# Kittitas County Community Development Services

## STAFF REPORT

**SUBJECT:** Vistas Views Estates 187-Lot Plat (P-05-03)

**Proposal:** Preliminary Plat Application – Vistas Views Estates 187-Lot Subdivision

VISTA VIEW ESTATES PTN. SE 1/4 OF SECTION 1, T.17N., R.18E., W.M. KITTITAS COUNTY, STATE OF WASHINGTON

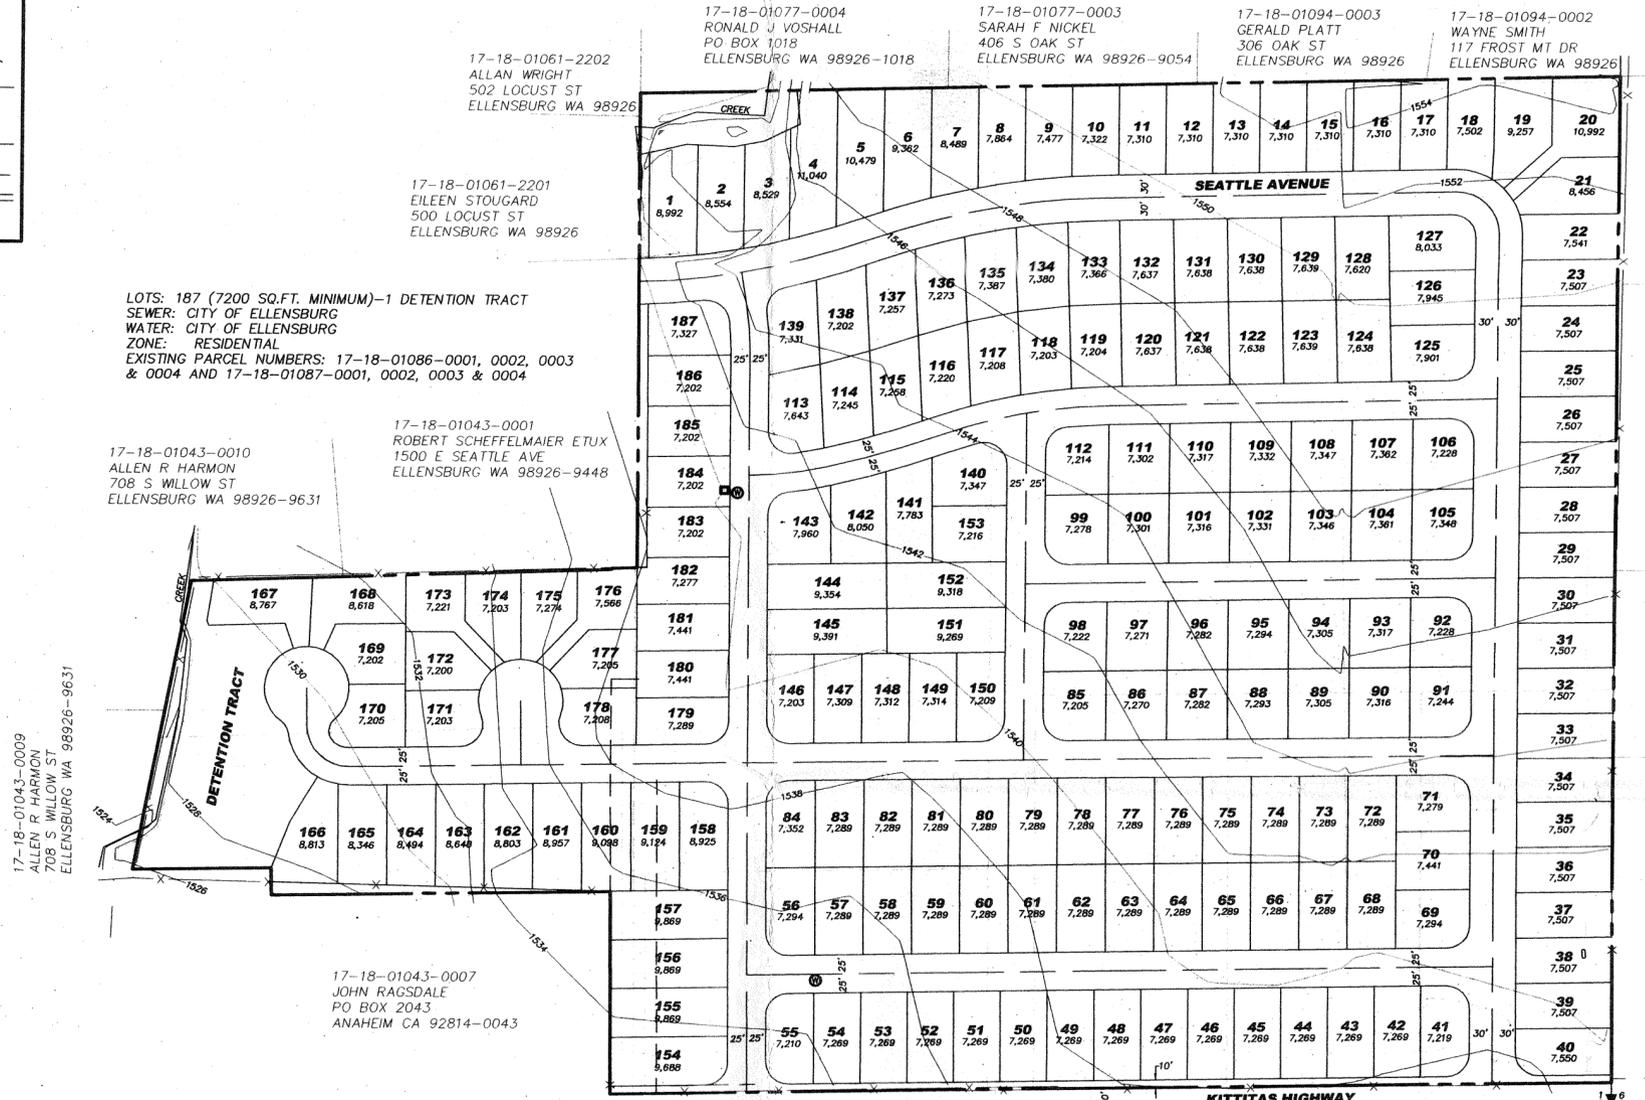
- k. The preliminary plat indicates a detention area for storm water detention and flow control. Specific issues related to storm water will be reviewed at time of civil plan submittal.

- f. Lots 40 through 55 and Lot 154 shall not access Kittitas Highway; access shall be on the internal road system.
- g. The lots adjacent to Kittitas Highway shall have their driveway access along the interior streets. Driveways accessing onto arterial streets are discouraged, and to the greatest extent possible in plat design, access should be organized along neighborhood streets that may intersect arterials, i.e. cul-de-sacs, loops and neighborhood collectors.

- l. In addition to the Seattle Avenue right of way connection, a road right of way shall be stubbed out to the north boundary line for a future connection to Oak Street.
